CITY OF ALBUQUERQUE

July 2, 2019

Re: Louisiana building refresh
2440 Louisiana Blvd NE Albuquerque NM
Traffic Circulation Layout
Engineer's/Architect's Stamp 06-14-19 (H19D001)

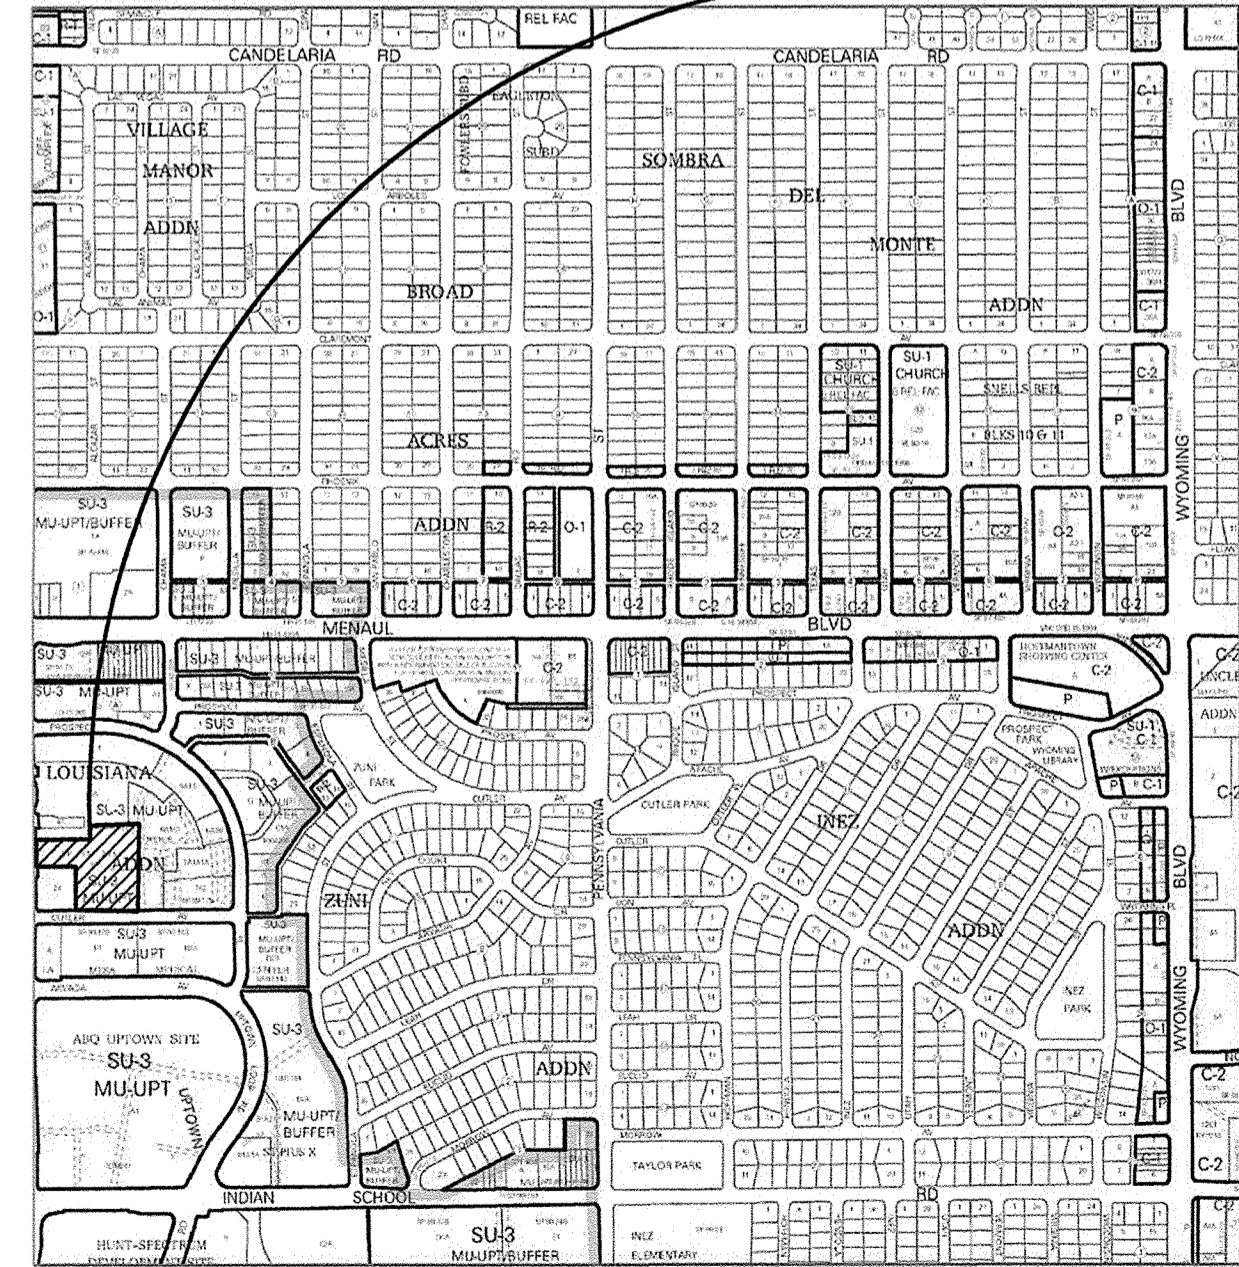
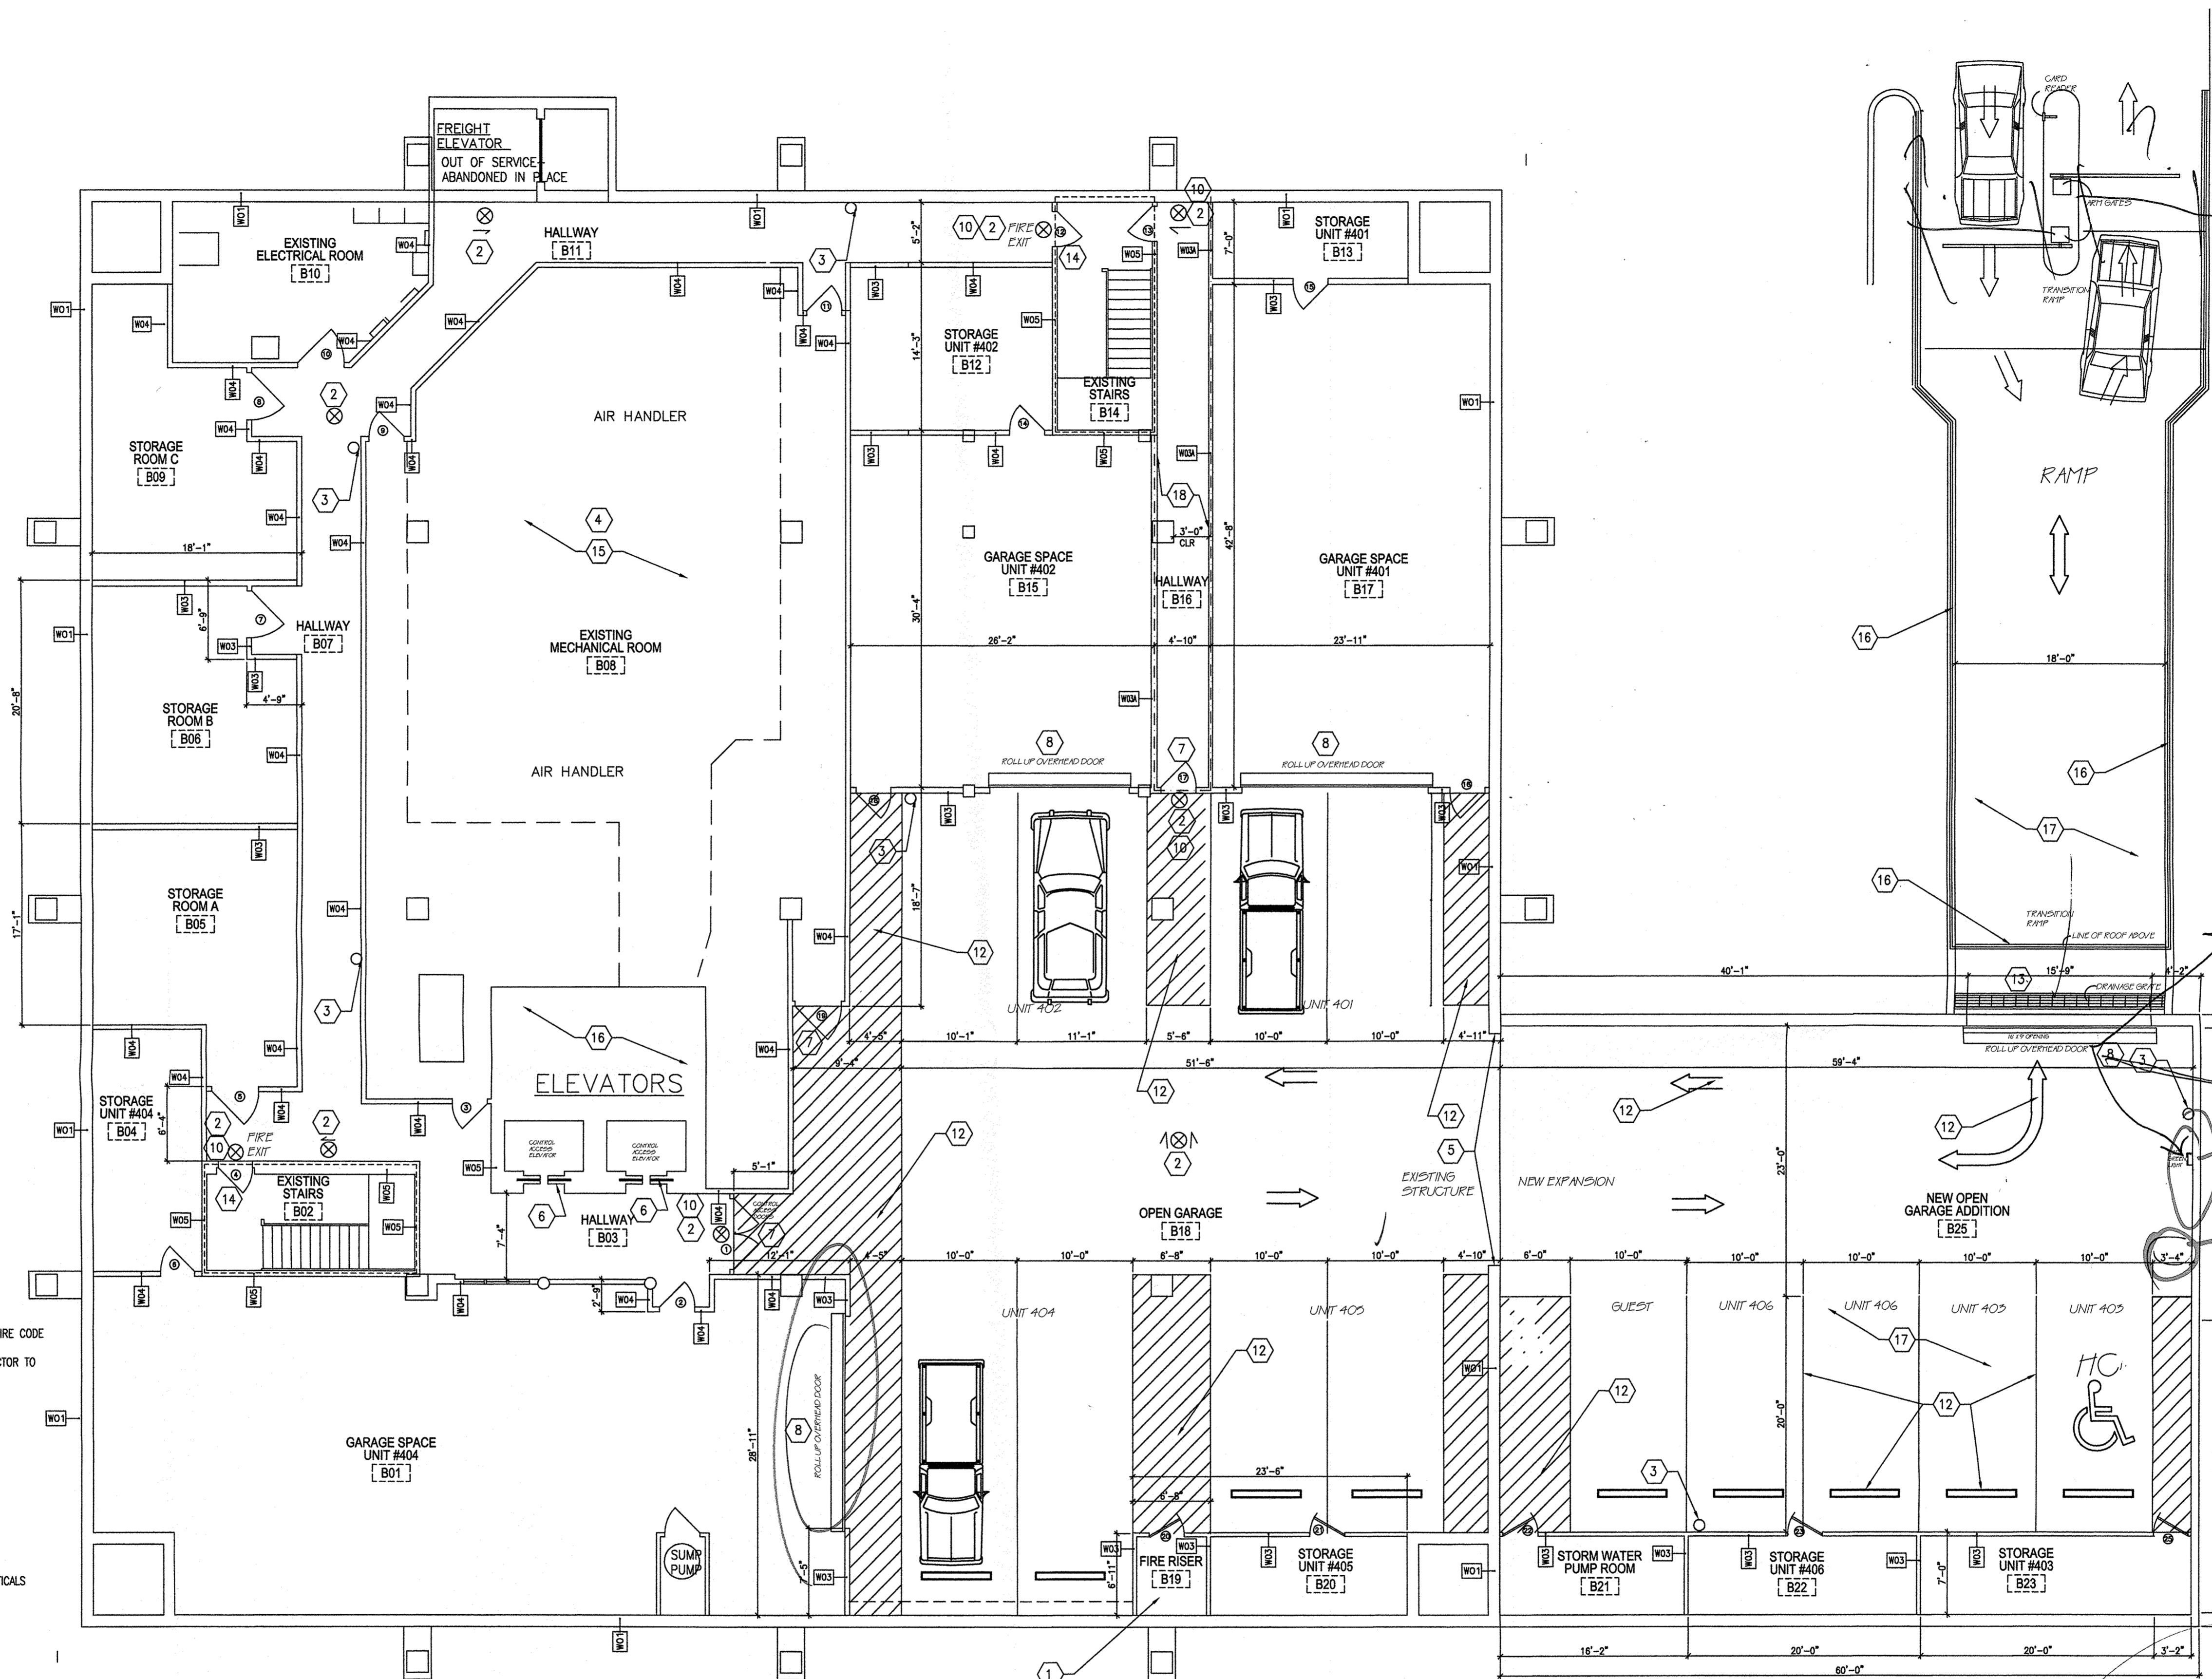
1. There are eight ADA spaces while the table mentions that there are 12.
2. Please list the width and length for all existing and proposed parking spaces. Some dimensions are not shown.
3. The ADA accessible parking sign must have the required language per 66-7-352.4C NMSA 1978 **"Violators Are Subject to a Fine and/or Towing."** Please call out detail and location of HC signs.
4. The ADA access aisles shall have the words **"NO PARKING"** in capital letters, each of which shall be at least one foot high and at least two inches wide, placed at the rear of the parking space so as to be close to where an adjacent vehicle's rear tire would be placed. (66-1-4.1.B NMSA 1978)
5. Please remove the fire lane striping from behind the parking spaces. Traffic department do not approve of any striping behind the parking spaces.
